This is to certify that C PORT CREDIT UNION

Located At 285 FOREST AVE

Job ID: 2012-03-3448-SIGN

has permission to Install 99 sf pylon sign & two wall signs

A DOUBLE FACE INTERNALLY ILLUMINATED PYLON SIGN
SCALE: 3/8" = 1'-0" (1) REQUIRED

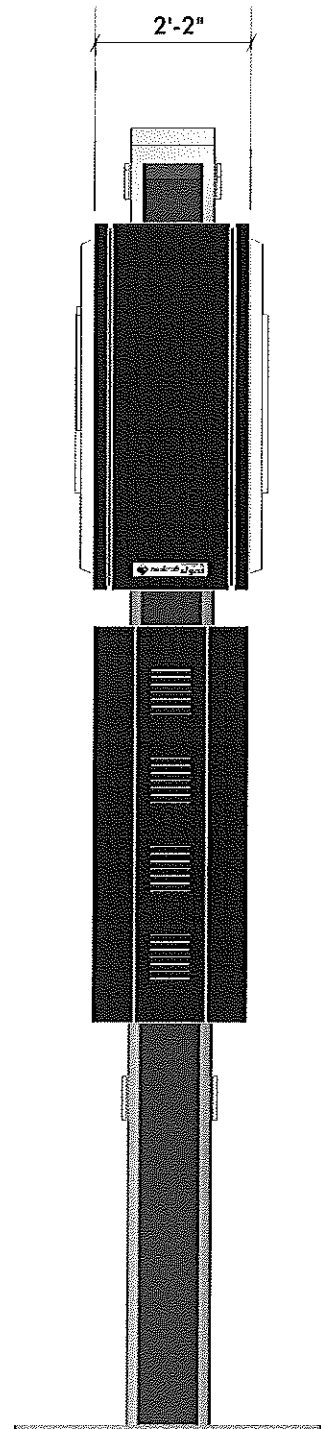
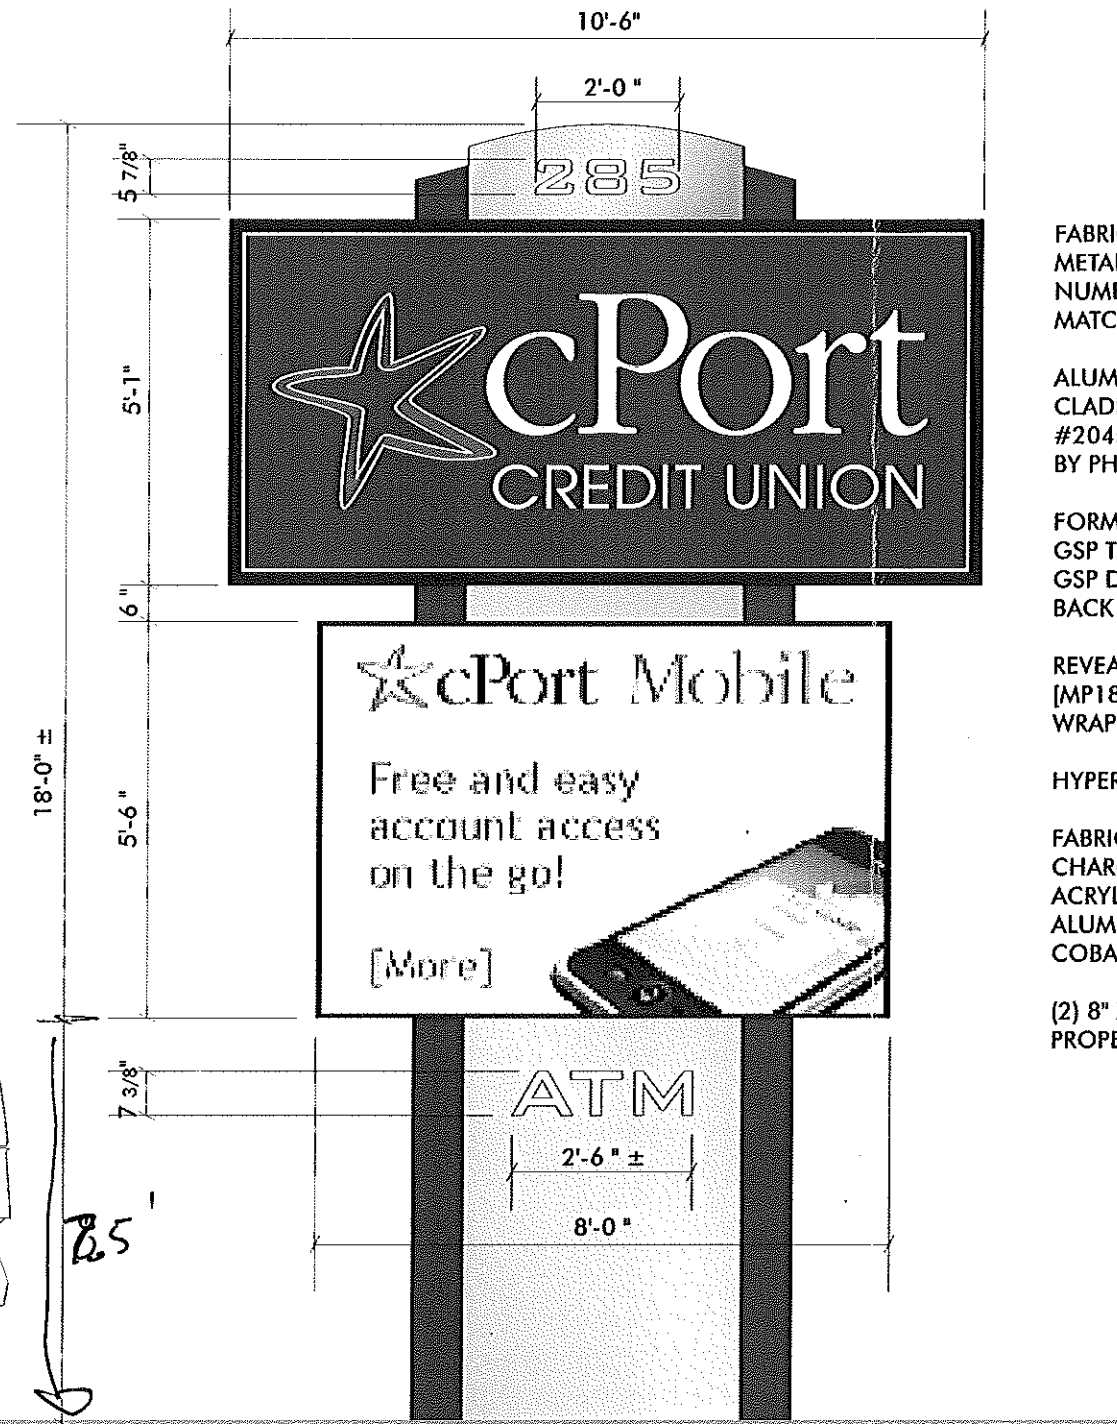
Regarding the proposed 100 square foot pylon sign, we request a waiver (as previously requested in Northeast Civil Solutions' letter dated 7/29/11) to the signage limit because we feel the Hannaford Drive road should be incorporated into the road frontage calculation for the cPort Credit Union site. If it were, our pylon sign would be well within the regulations. We feel this is a technicality since the Hannaford Drive road is not considered a public road even though it is a highly trafficked route by the public. This issue was discussed with Marge Schmuckal during the site approval process.

3-7-12 Pylon sign exceeds maximum square footage - 65 sf allowed, 98.91 proposed. Total square footage of wall signs exceeds the maximum cumulative area allowed – Max sf allowed is 150 sf & two proposed wall signs add up to 200.15sf. Spoke to Mason Rowell at Landry French. He will send a letter appealing it with a \$75 fee. –amachado

B INTERNALLY LIT WALL ID (MAIN) (68 sq. ft)
SCALE: 1/4"=1'-0" (1) REQUIRED

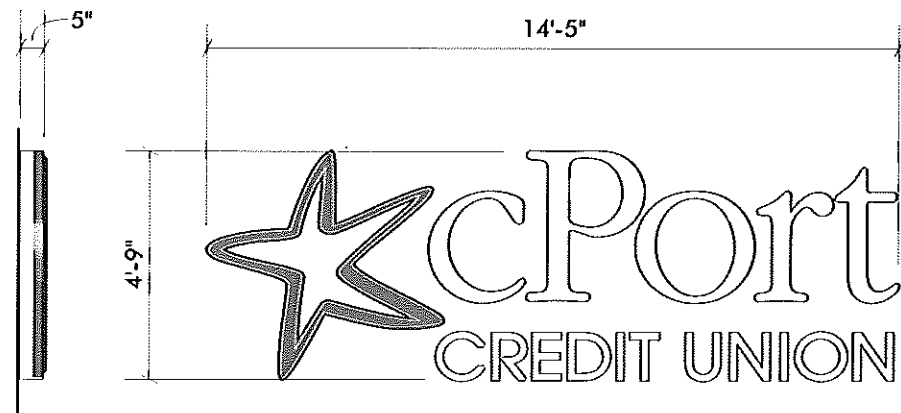
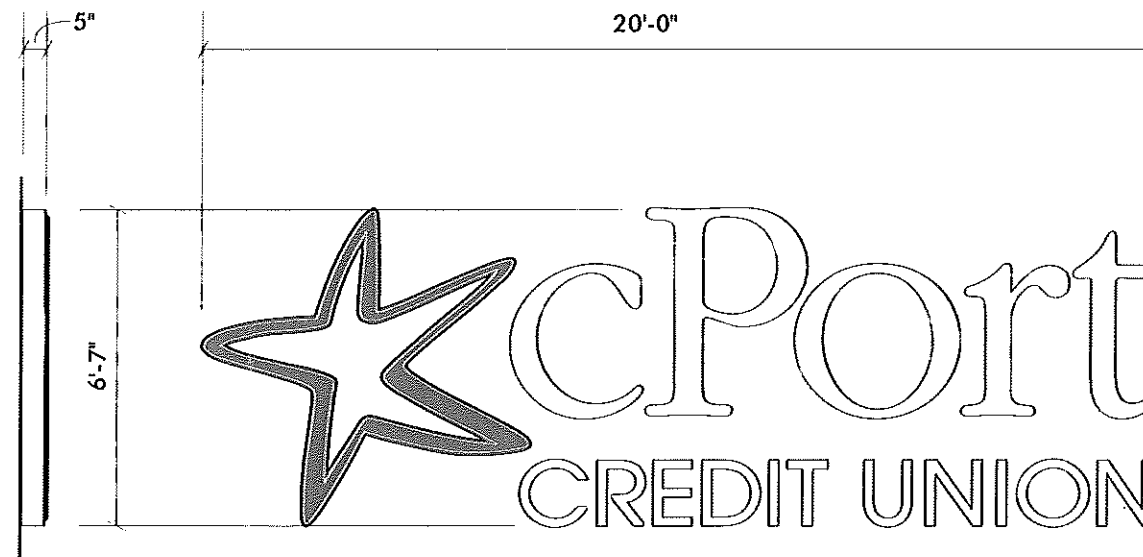
Regarding the building signage, we recognize that one face of the building has a frontage of approximately 88 linear feet, which would limit us to 150 square feet of cumulative signage per the City of Portland's regulations. However, we request that a waiver is granted to allow for the installation of the 200 square feet of signage depicted in the drawings, as our branch will have two principal entry facades. With two principal entry facades facing two separate streets, we believe that this would make the branch 'eligible for the full amount of signage relative to its frontage, notwithstanding the maximum cumulative sign area', or 225 square feet.
